CONSULTEE RESPONSE (Council's Arboriculturist)

Reference: FG/5/26/T

Location: 43 Ferringham Lane, Ferring, BN12 5NB

Proposal: Crown reduction to 1no. Monterey pine (T1) to leave a southerly spread of 8.25-8.5m and a south westerly spread of 7.5-8m. Removal of 1no. 'hazard beam' at 6m on west side and 1no. branch at 8m on South side.

Photograph 6: below right, showing a close up of the 'hazard beam' formation.

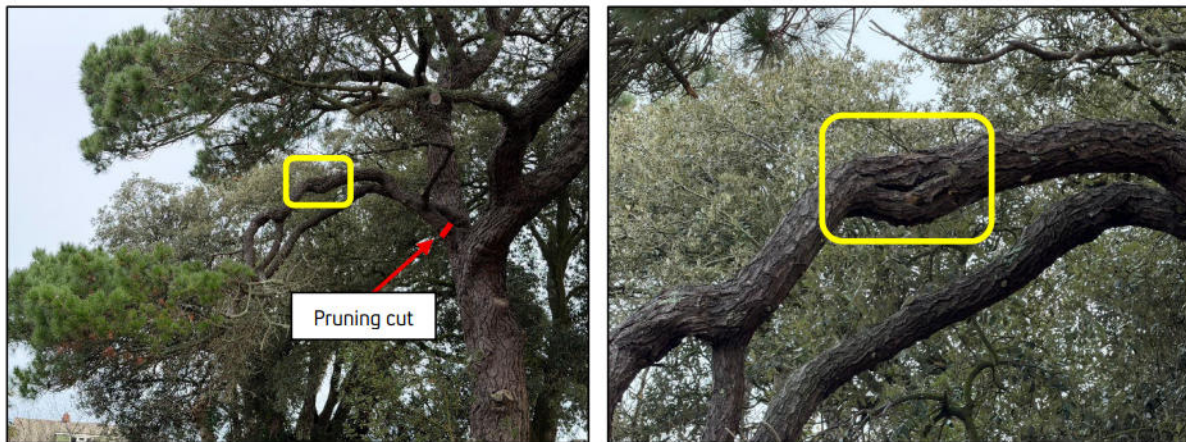
Removal of the low split limb ('hazard beam') is necessary and will not incur a loss of amenity.

- Removal of 1no. 'hazard beam' at 6m on west side, 1no. branch at 8m on south side and removal of pinecones, to 1no. Monterey pine (T1)

Photograph 7: showing pruning requirements to reduce the likelihood of cone fall causing further damage or injury to 43 Ferringham Lane.

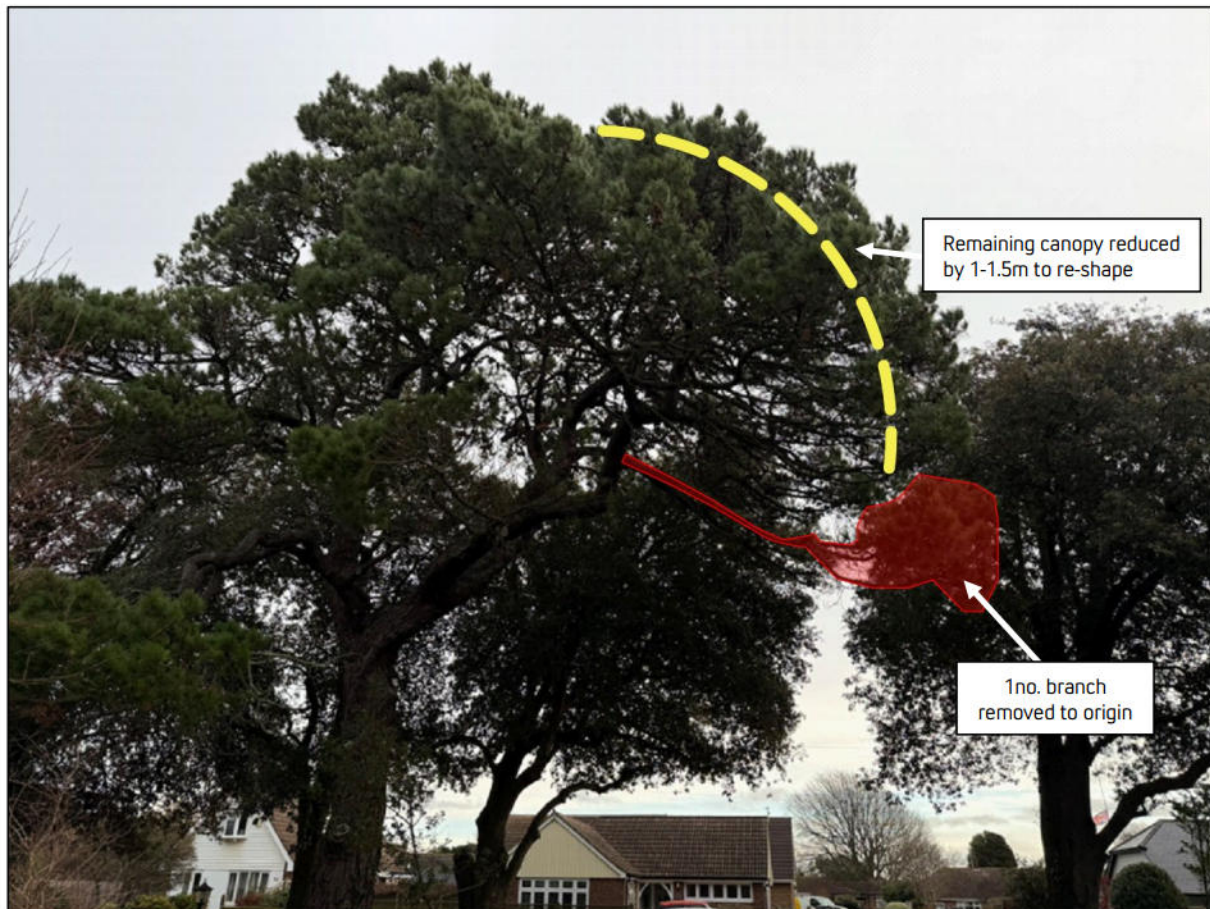
The reduction in length of high branches across the crown carries a risk of harm to the tree's long-term vitality and loss of visual appeal.

The Arboricultural Association provides the following advice: *Pine trees have a poor tolerance of hard pruning. Any pruning should be avoided if possible as buds form only at shoot tips. Newest growth can be removed during the spring.*

The tree is a significant feature in the local landscape and appears to be in adequately sound and healthy condition. A majority of the tree surgery proposed in the application would likely result in undue harm to vitality and undue detriment to the visual amenities of the locality.

The risks presented by this tree can be managed to a reasonable level by regular inspection, pinecone removal as an alternative to upper crown branch reduction pruning and a precautionary approach to use of land beneath the canopy.

As it stands, I am unable to support this application. I **would like the applicant invited to agree to an alternative proposal for lesser works (as described below) as part of the current application so as not to incur further delay.** Such work would go some way to addressing the applicant's concerns whilst ensuring no detriment to tree health or loss of amenity:
